SCOTTISHPOWER
RENEWABLES

East Anglia ONE North and East Anglia TWO Offshore Windfarms

Applicants' Comments on Natural England's Deadline 6 Submissions

Applicant: East Anglia TWO and East Anglia ONE North Limited
Document Reference: ExA.AS-9.D7.V1
SPR Reference: EA1N_EA2-DWF-ENV-REP-IBR-001338

Drg No	EA2-DWF-ENV-REP-IBR-000920		
Rev	3	Datum: WGS 1984	
Date	30/08/19	Projection: Zone 31N	
Figure	28.21c

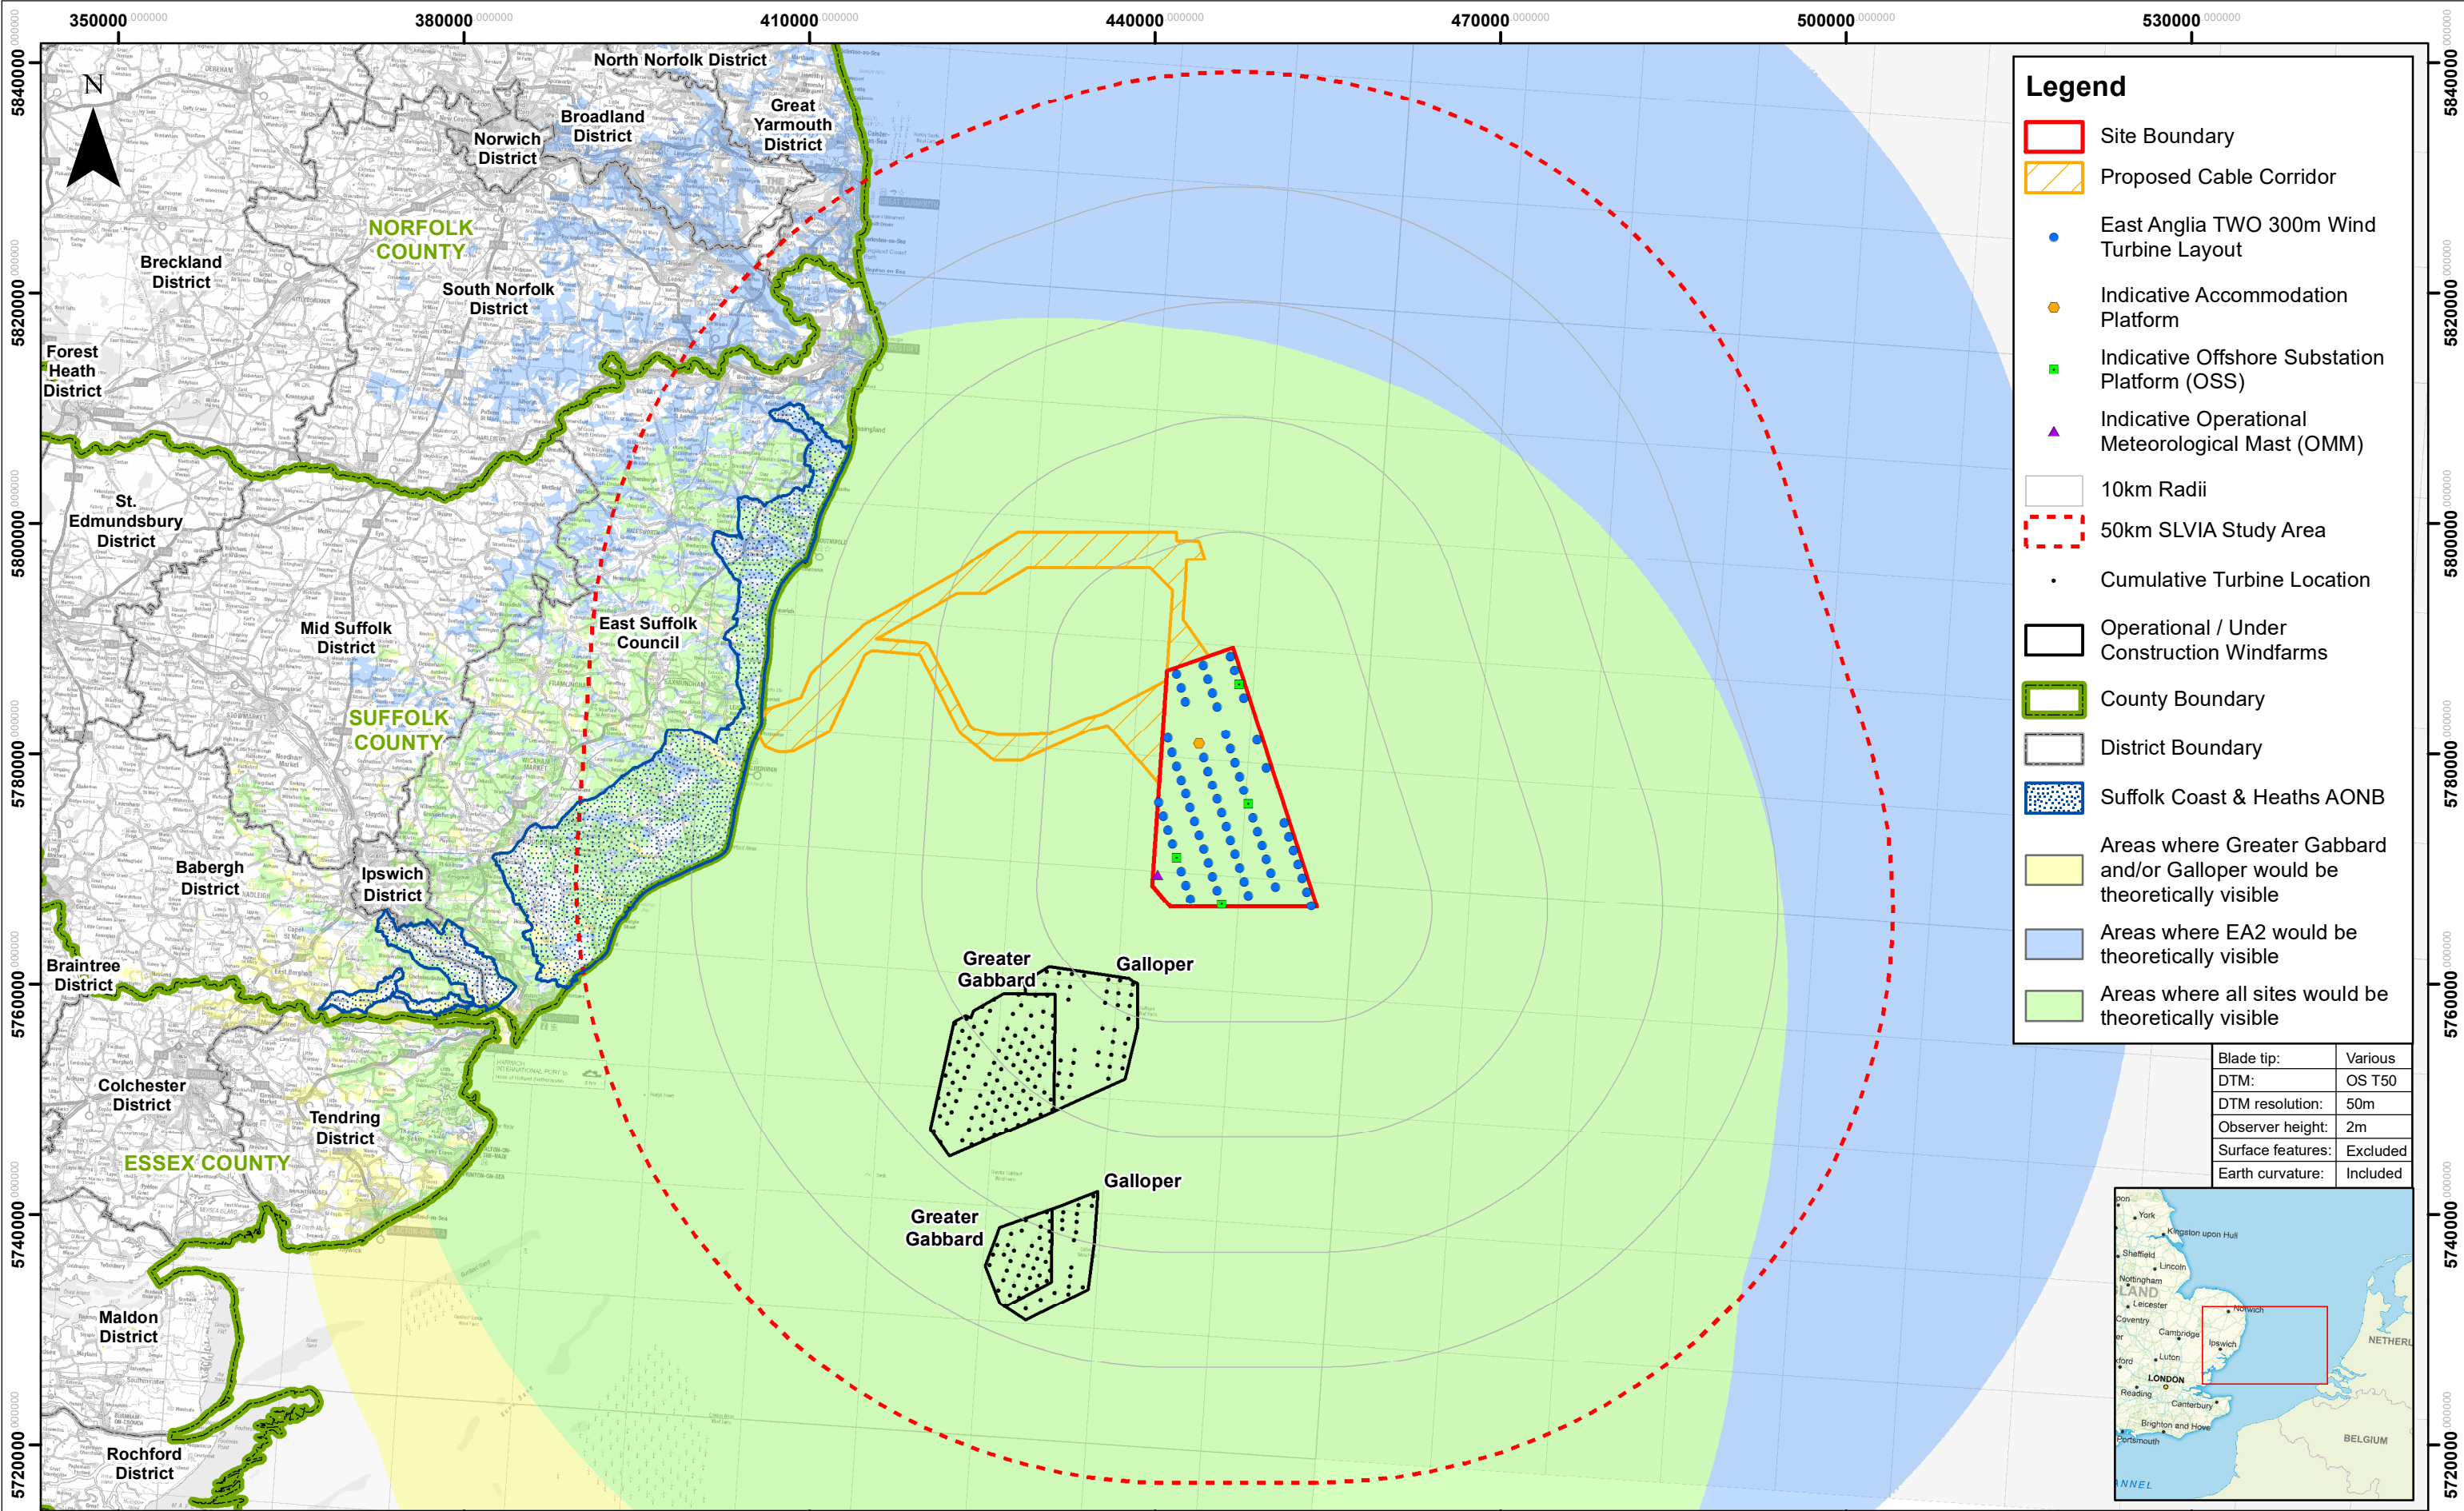
Ref	NE Comment	Applicants' Comments																				
030	29. For the reason set out above, directly comparing the physical influence of the EA2 scheme with those of other offshore arrays located off the coast of other designated landscapes is unhelpful. We have already provided commentary on the nature of the relationship between the Rampion windfarm and the 1,500m of coastline of the South Downs National Park at Rottingdean. We will not be providing any further commentary on this example.	No further comment																				
031	<p>30. In our advice Natural England have, and will only, make reference to the visual influence of the of the Greater Gabbard and Galloper arrays on the SCHAONB as a means of understanding the effect of the turbines of EA2. For completeness, here are the apparent height values for these arrays, noting that the EA2 turbines will appear to be taller than those of both Greater Gabbard and Galloper, <u>despite the fact that they are located further offshore.</u></p>

<p>THE TURBINES OF EA2 WILL APPEAR TO BE TALLER THAN THE TURBINES OF GALLOPER EVEN THOUGH THEY ARE LOCATED FURTHER AWAY FROM THE COAST.</p>	Windfarm	Viewing height (m) (VP 18 Orford Ness)	Turbine height Blade Tip (m)	Minimum Distance (km) (as measured from Viewpoint 18)	Apparent height of closest turbine (degrees) NE Figure	EA2	5.8	282	37.4	0.352*	Greater Gabbard	5.8	134	25.1	0.268	Galloper	5.8	180	29.3	0.300	<p>The Applicant notes the commentary on apparent height it has provided in the Applicant's Comments on Relevant Representations - Volume 3: Technical Stakeholders (AS-036). The Applicant notes that based on the apparent height values provided in the table opposite, the turbines of the East Anglia TWO windfarm site are very similar and only marginally taller than the turbines of Galloper (by a vertical angle of 0.052°) and that this similar apparent scale can be seen in the view from Orfordness as demonstrated in the wireline in ES Figure 28.42a-e (APP-372).</p>
Windfarm	Viewing height (m) (VP 18 Orford Ness)	Turbine height Blade Tip (m)	Minimum Distance (km) (as measured from Viewpoint 18)	Apparent height of closest turbine (degrees) NE Figure																		
EA2	5.8	282	37.4	0.352*																		
Greater Gabbard	5.8	134	25.1	0.268																		
Galloper	5.8	180	29.3	0.300

Ref	NE Comment	Applicants' Comments
032	31. Natural England advises that this is the only physical comparison which worthy of consideration by the ExA and therefore helpful in their deliberations. We advise that all other physical comparisons will be unhelpful and misleading.	The Applicants consider that looking at visual material in context is far more useful. A one dimensional analysis has very limited value. The appreciation of "Tallness" might be influenced by other scale comparators. Hence why a desk top exercise might be unhelpful or misleading in the extreme.
033	32. We advise therefore that the Applicant's text at paragraph 66 ii) and iii) is not relevant and contradicts previous statement made by the Applicant. For completeness this text is repeated below; 'The Applicant considers that judgements on significance should be properly based on the assessment material provided in the ES which have been undertaken with best practice GLVIA3'. ³	Comment provided below at row 034.
